Our Ref: EP/3/21/NMA

Non material amendment following the grant of EP/119/20/HH to simplify roof drainage & remove central downpipe.

Nutwood 5 Selhurst Close East Preston BN16 2SR

**Drg No:** 1647/20/P/02A

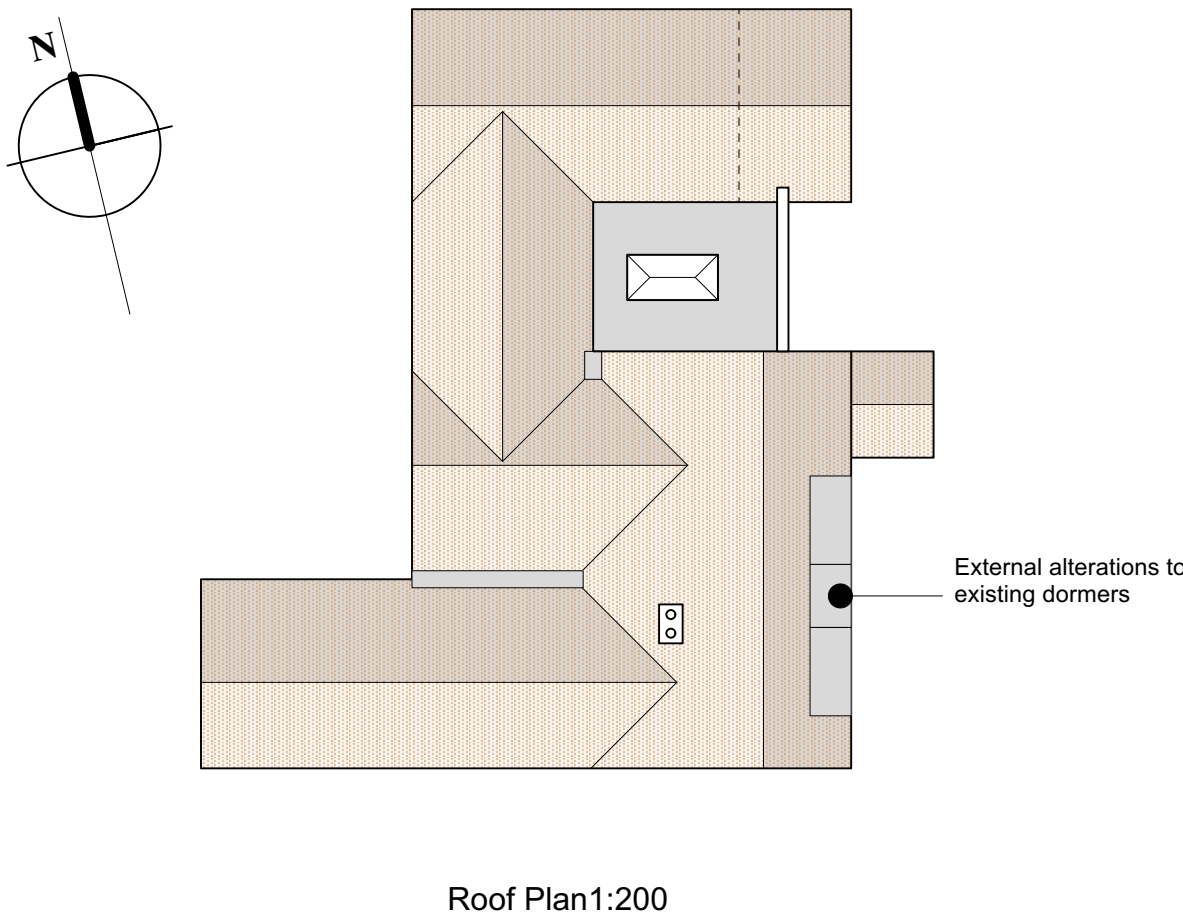
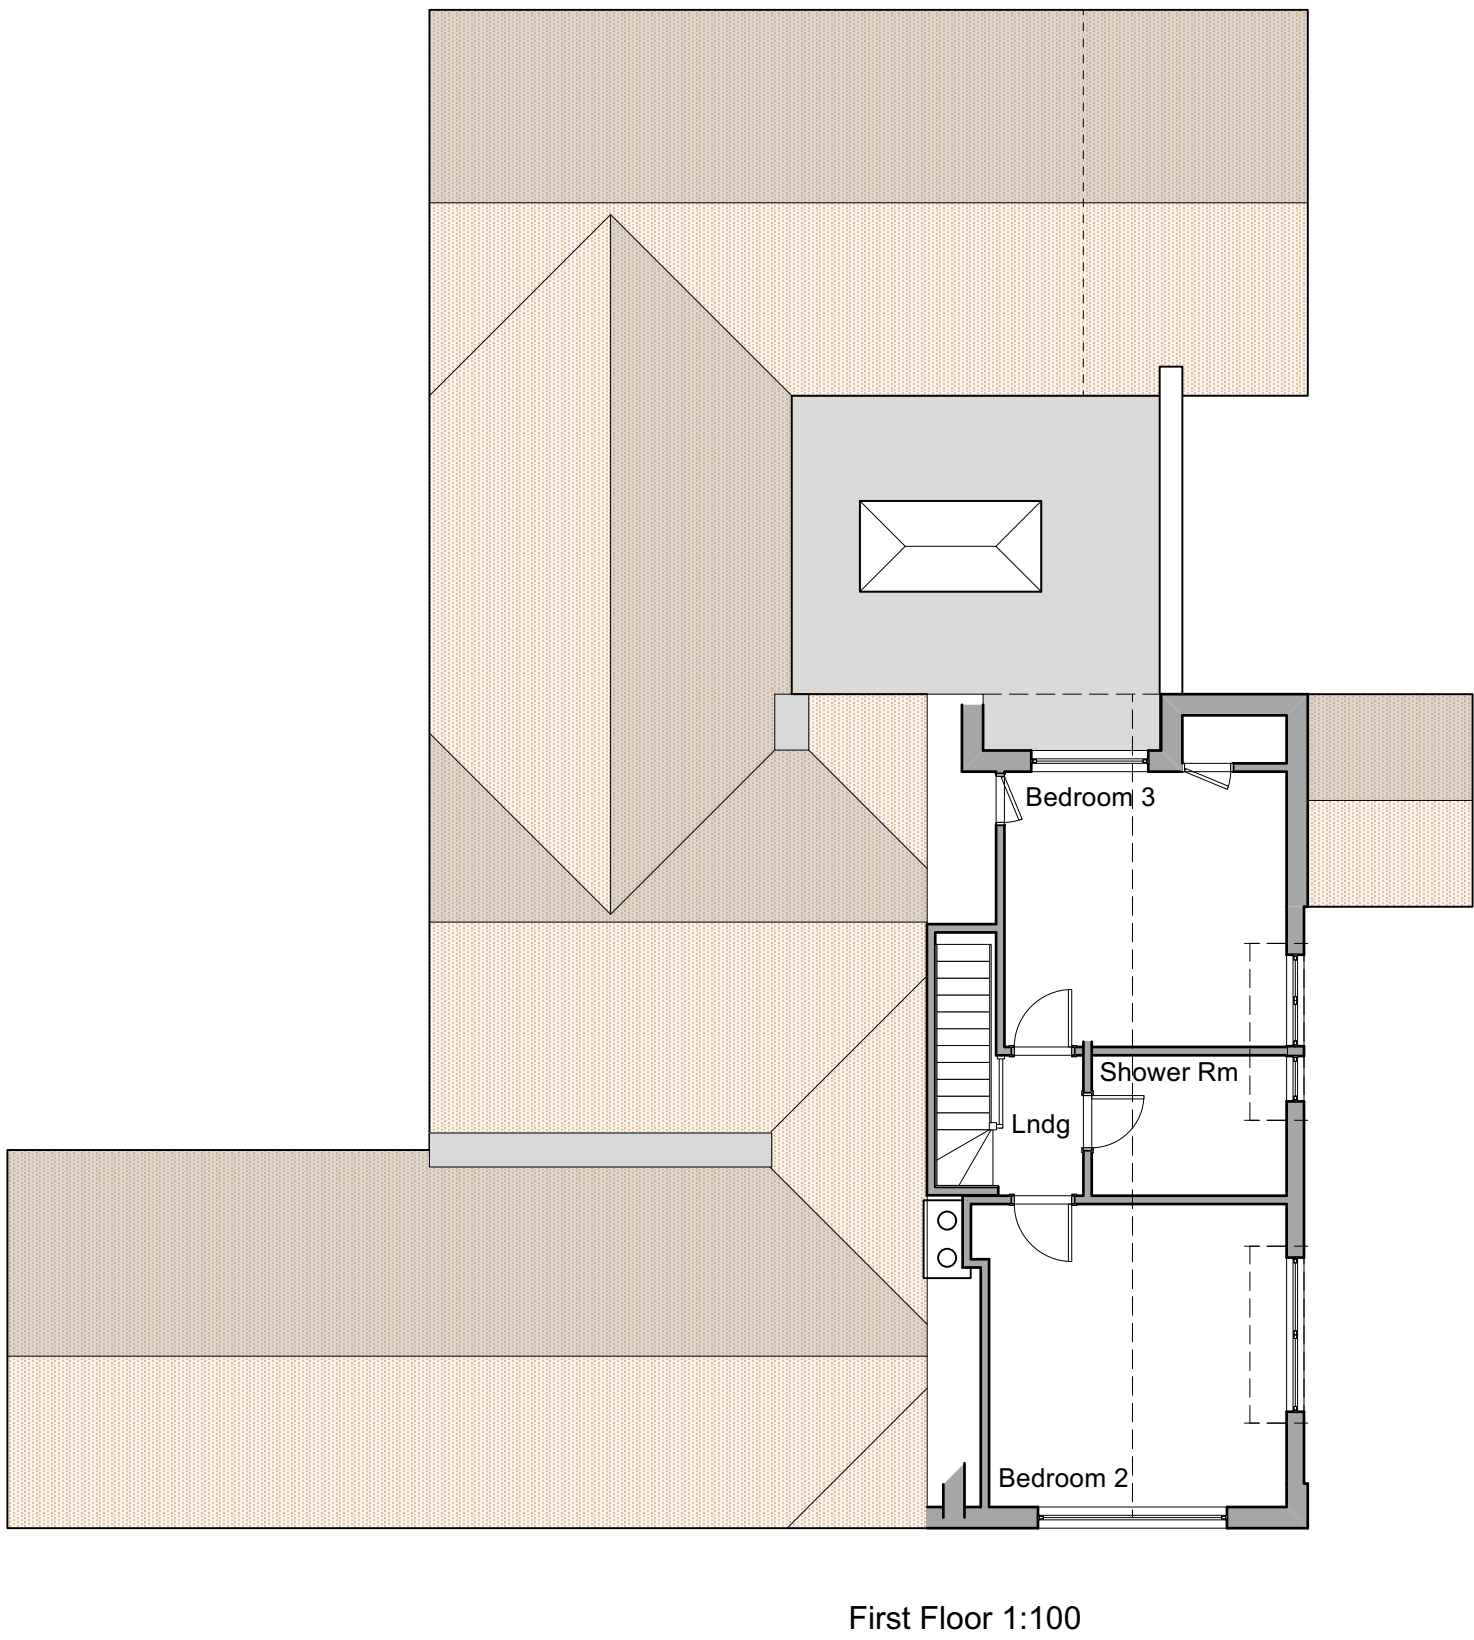
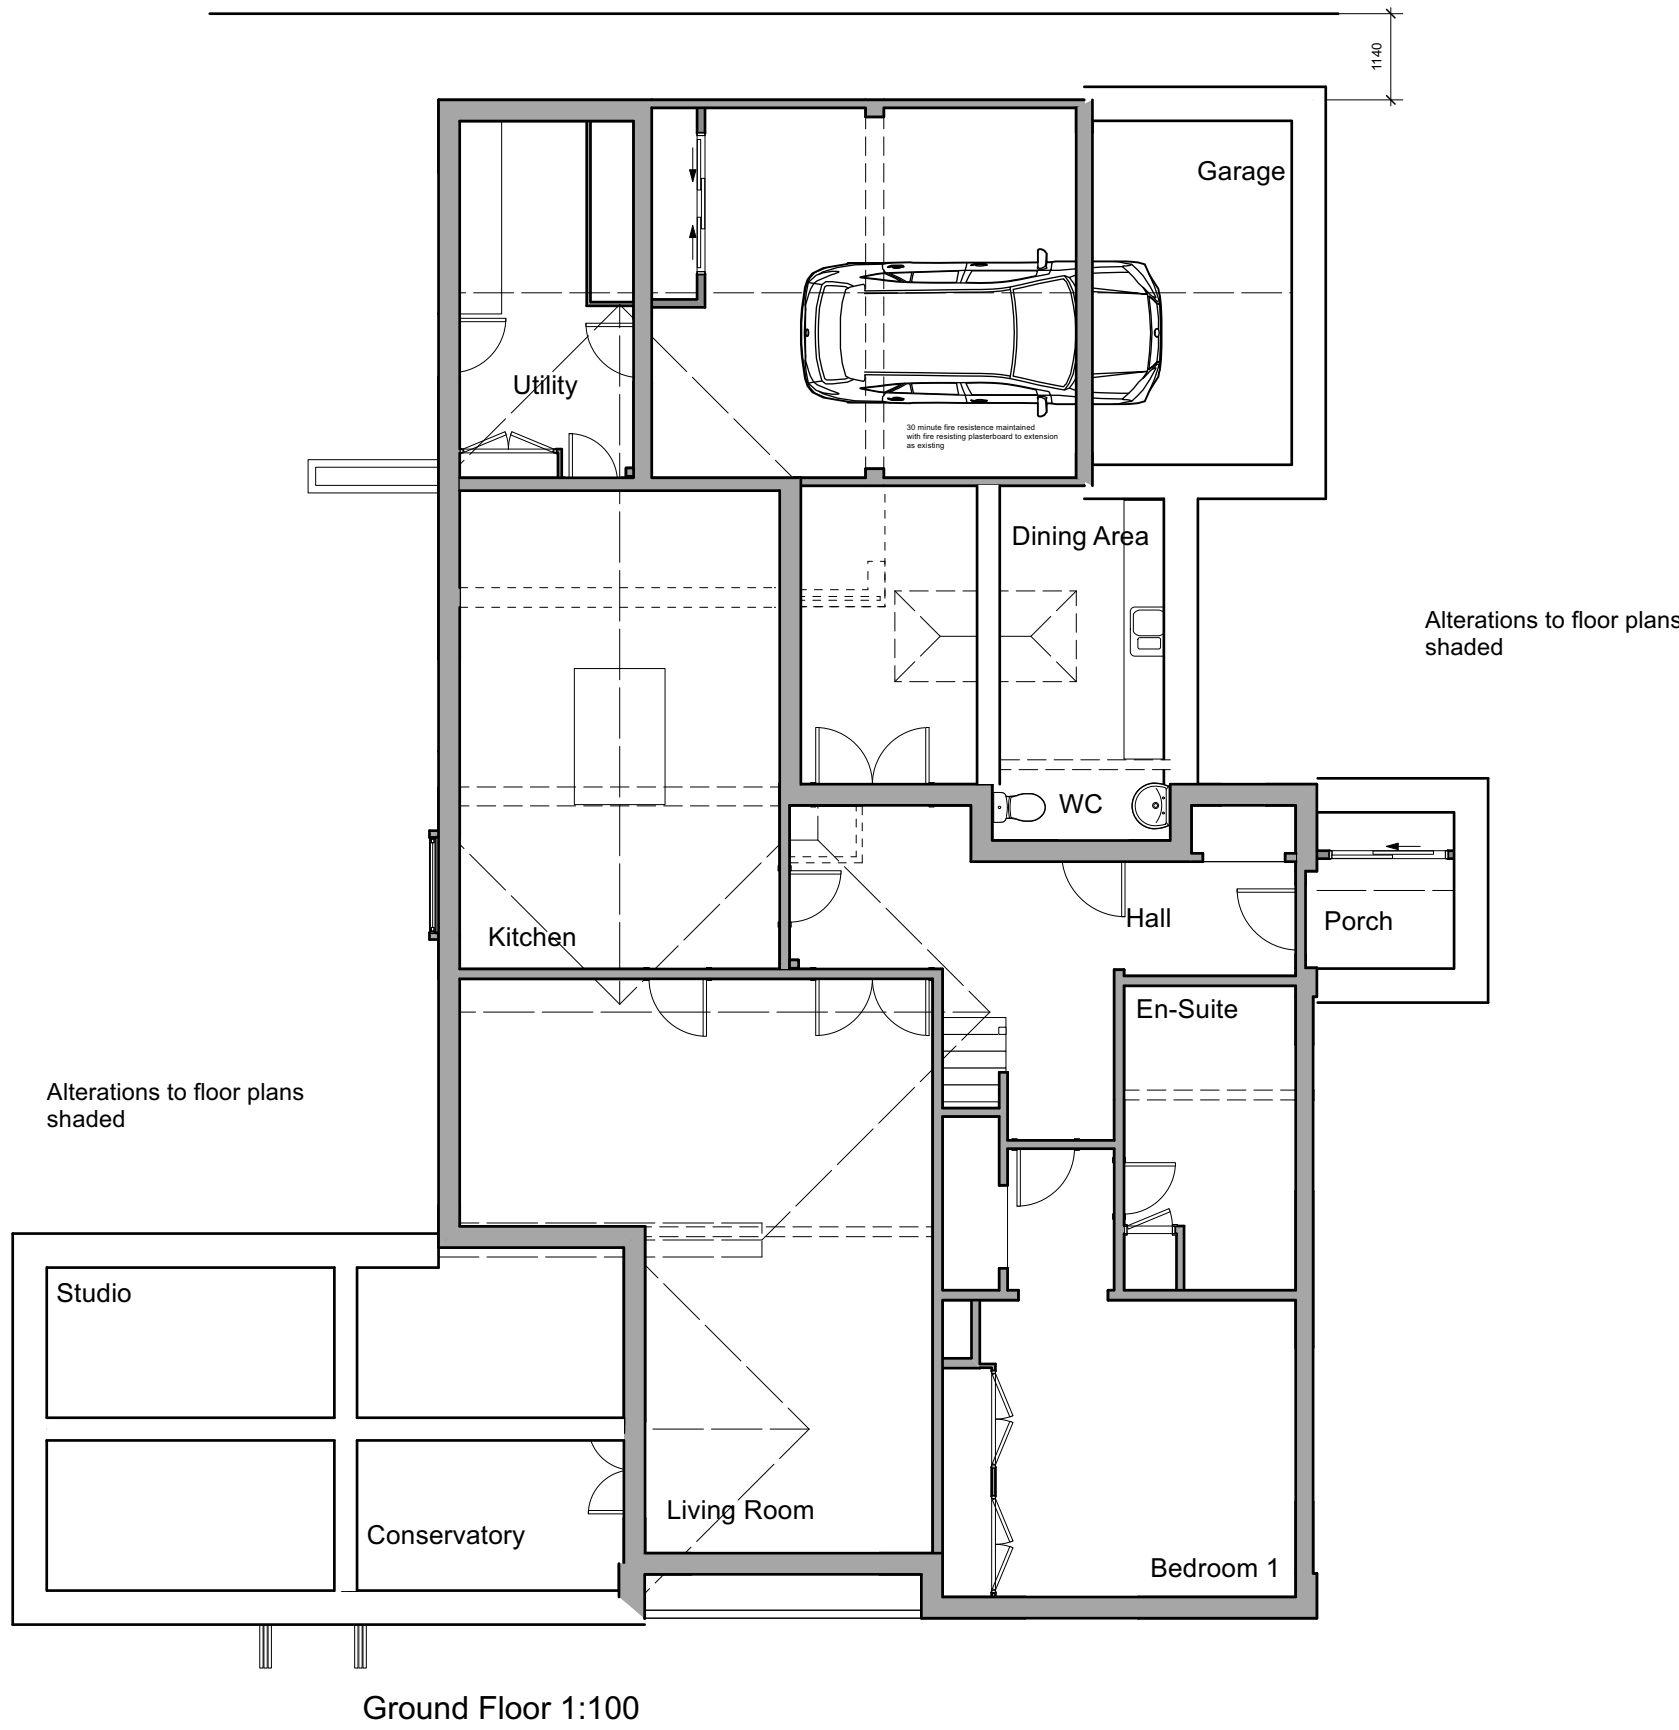
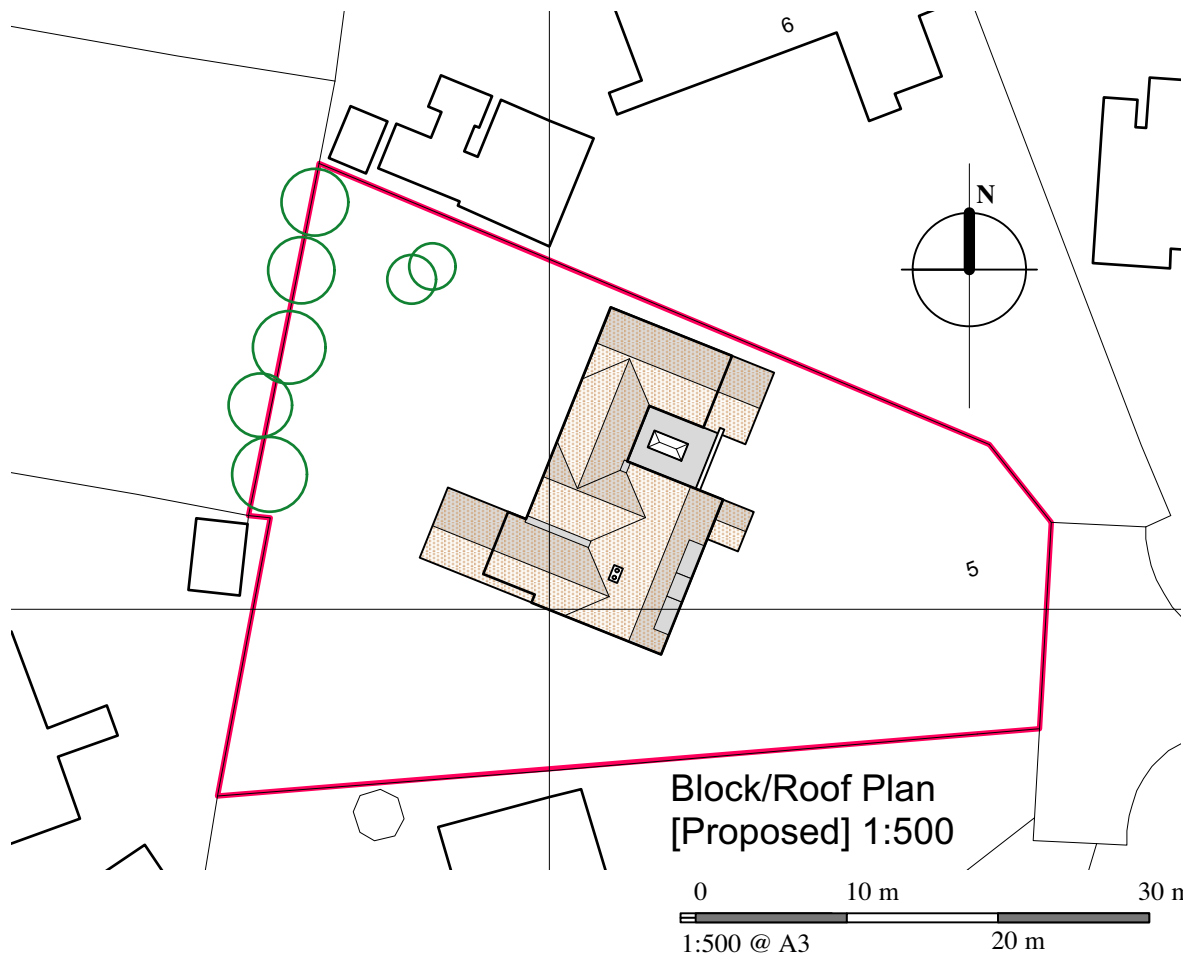
I refer to your recent application for a Non Material Minor Amendment. I note that you seek to simplify the roof drainage system, including the removal of the central downpipe.

Please note that plan references 'Location and Block - 1647/17/P/01A' and 'Proposed Plans - 1647/20/P/02' are hereby replaced by 'Location and Block - 1647/17/P/01B' and 'Proposed Plans - 1647/20/P/02A'.
